Your Ref: 000013945
Our Ref: BR/244/12/ 24-09-2012
Please ask for:
Miss K Rawlins

Erection of rear conservatory, erection of new front & side fence & alterations
23 Devonshire Road Bognor Regis

Thank you for your internet representation made on 25th October 2012 which has been recorded as **an objection** with the comments as follows:

DRAWING	SCALE
PROPOSED ELEVATIONS	1/100
DATE: MAY 2012	
DRAWN: T. Murray	
DRAWING: 12/228	REVISION:

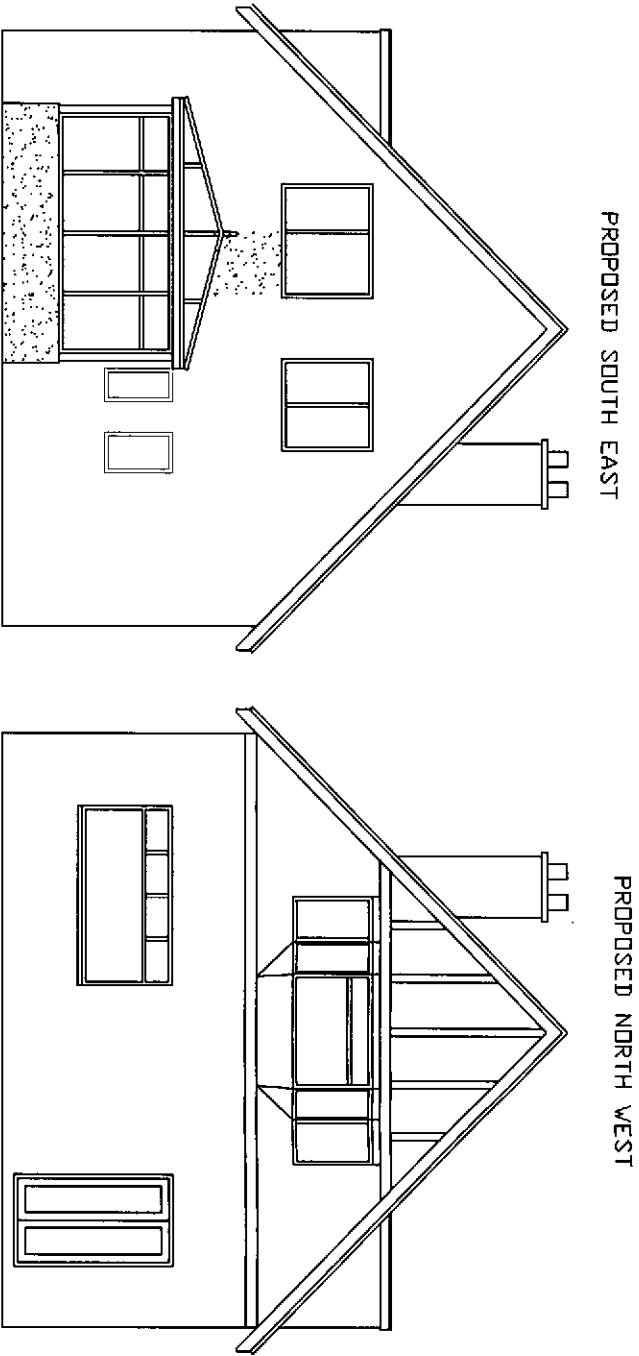
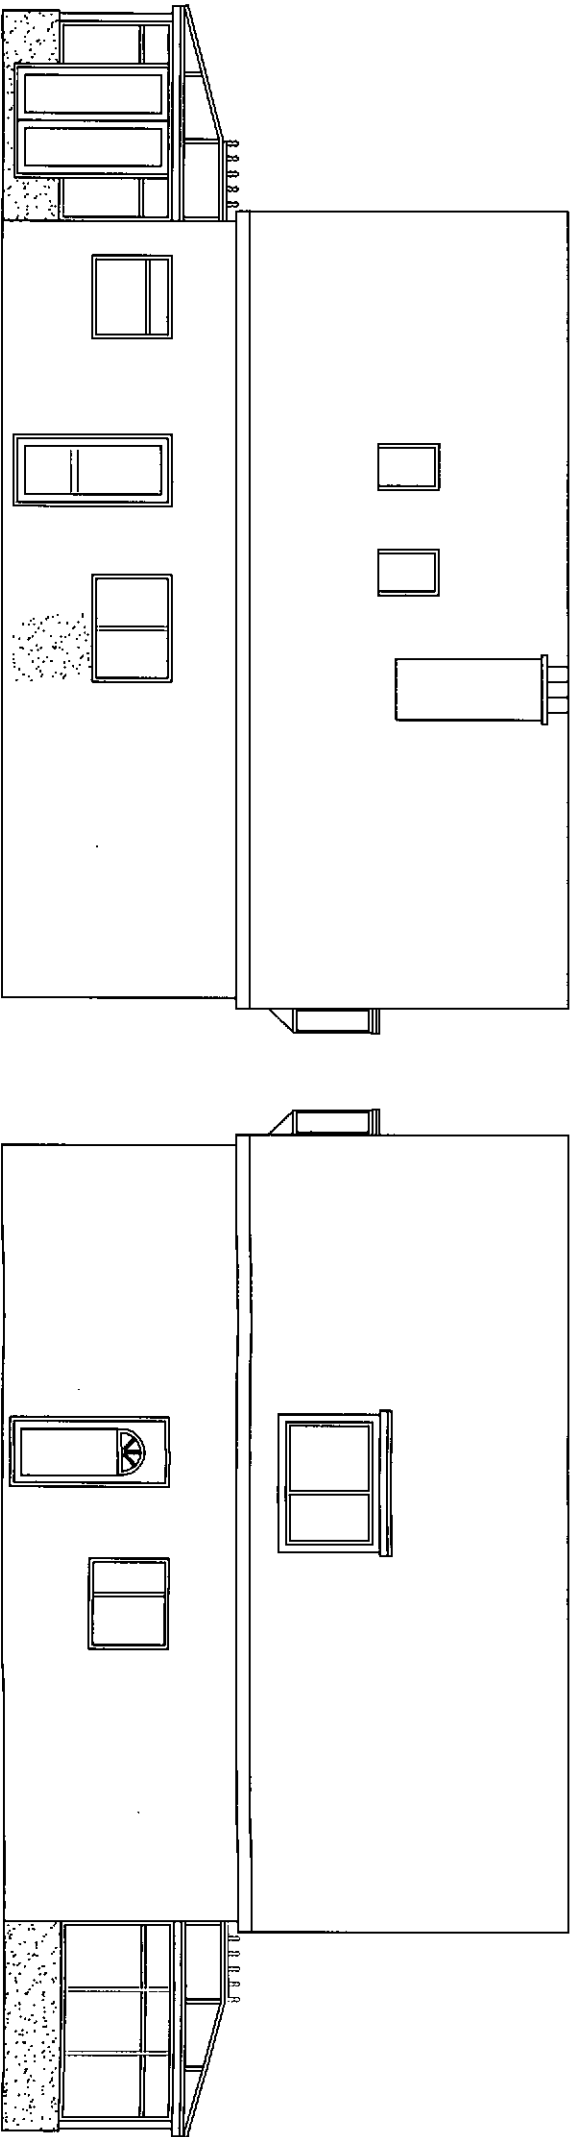
After looking at the planning application for wood fencing around the front of 23 Devonshire Road the application is far too high and is on top of the brick wall that is already there. □

Trellis on top is ridiculous and the high fencing is out of character of all the surrounding houses which have far lower fences. It will look like a prison yard for exercising in and being such a small area will look terrible for the rest of the road. A lower fence would make far more sense if privacy is what is required. Mrs A. Farmer 29 Devonshire Road □
